Subject: B7 Design Review – 20 Marginal Way

Written by: Caitlin Cameron, Urban Designer

Date of Review: Wednesday, June 10, 2015

AE202

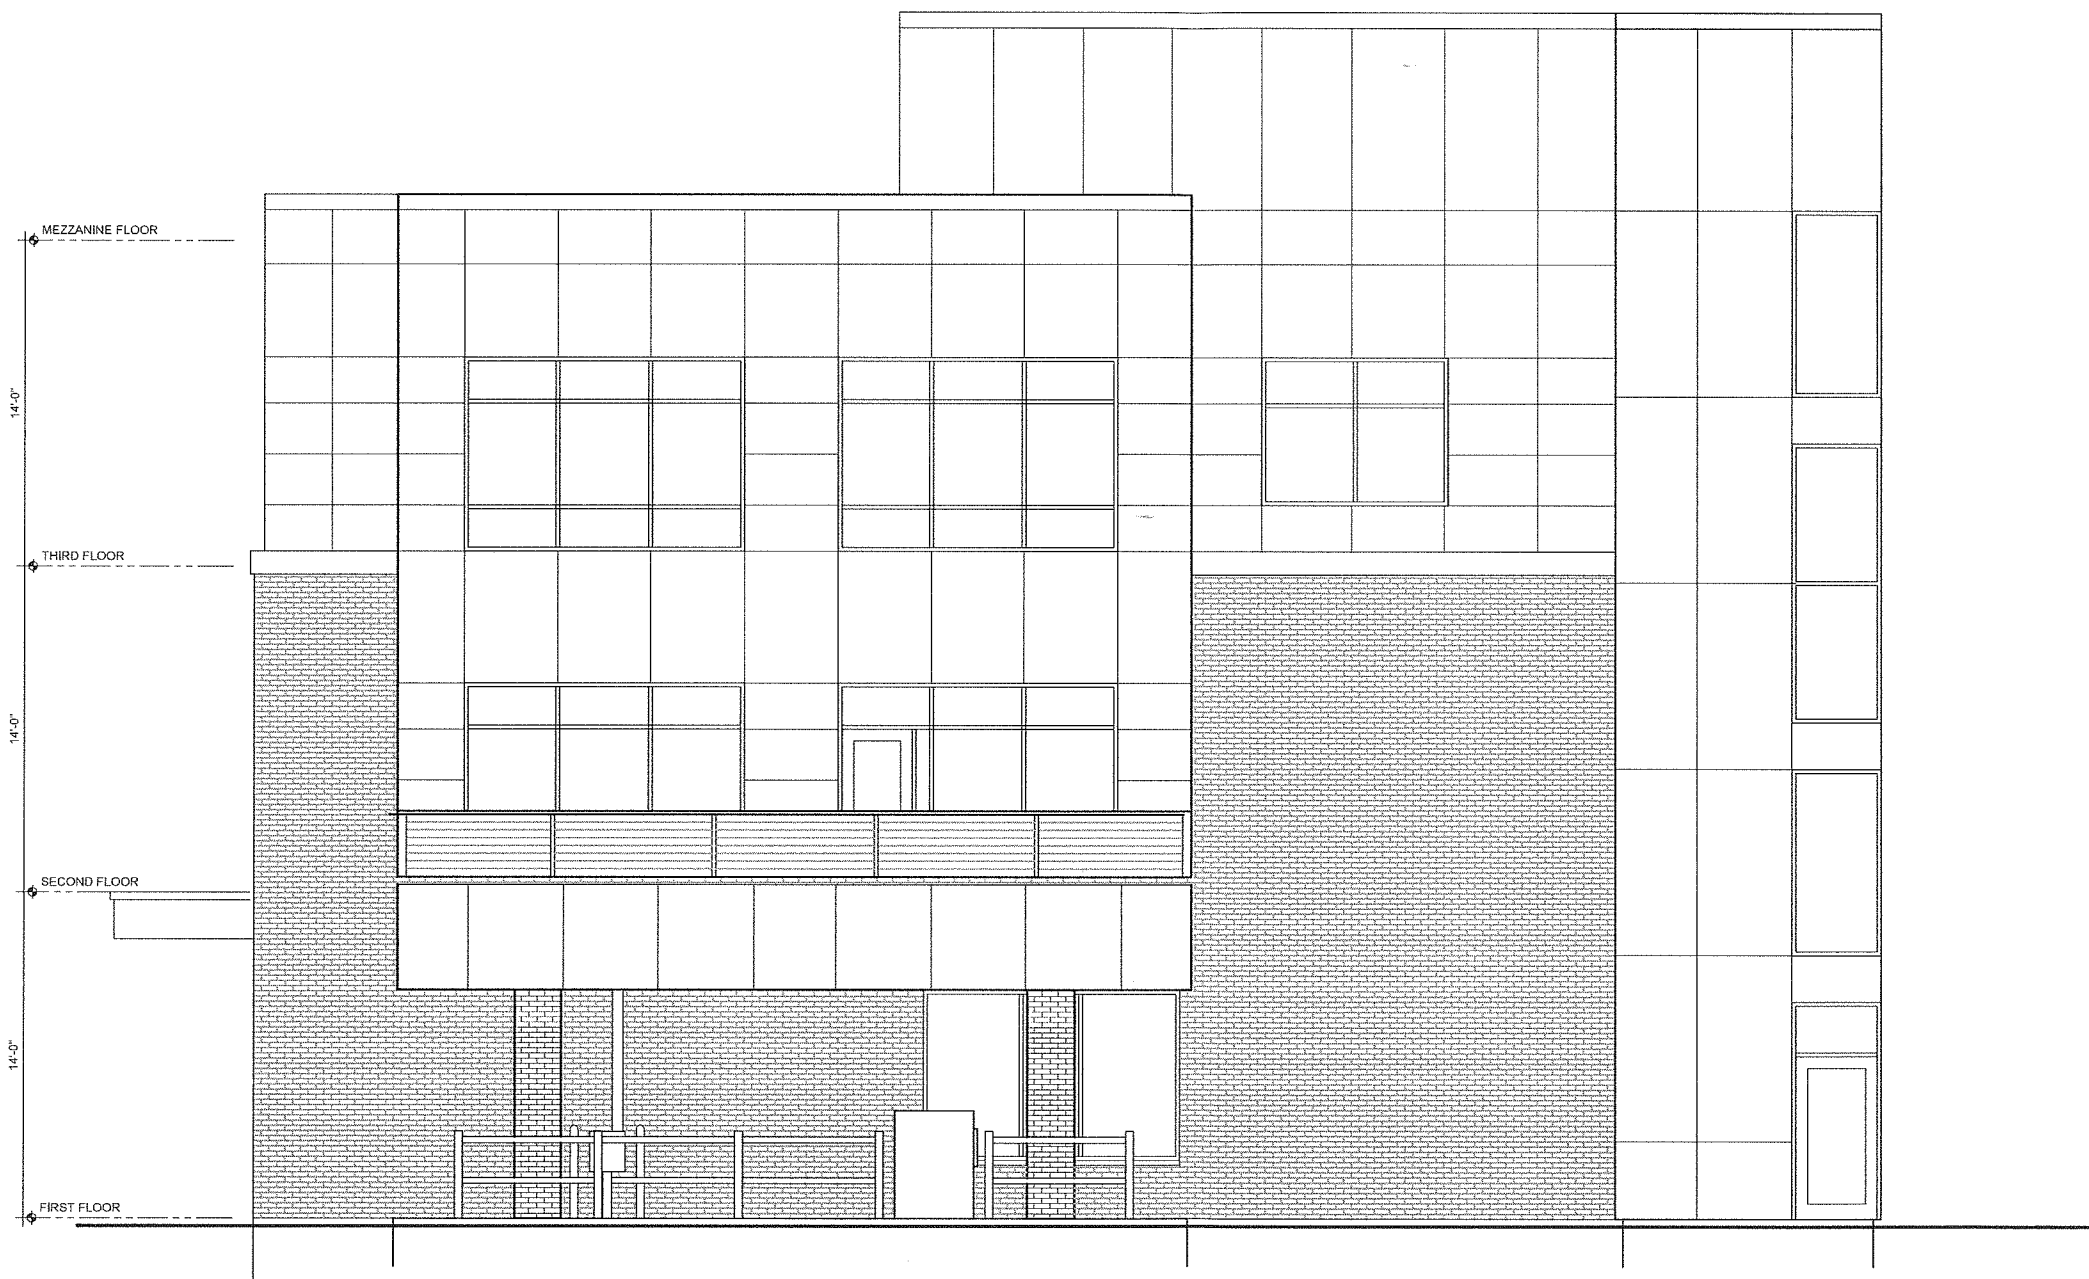
- The proposed façade design facing the street is awkwardly proportioned and does not create a balanced façade composition. Staff proposes the composition be adjusted using the material and belt line placement as suggested in the attached sketches. This is one suggestion to adjust the façade proportions – the design team/applicant may propose other alternatives that achieve the same objective.
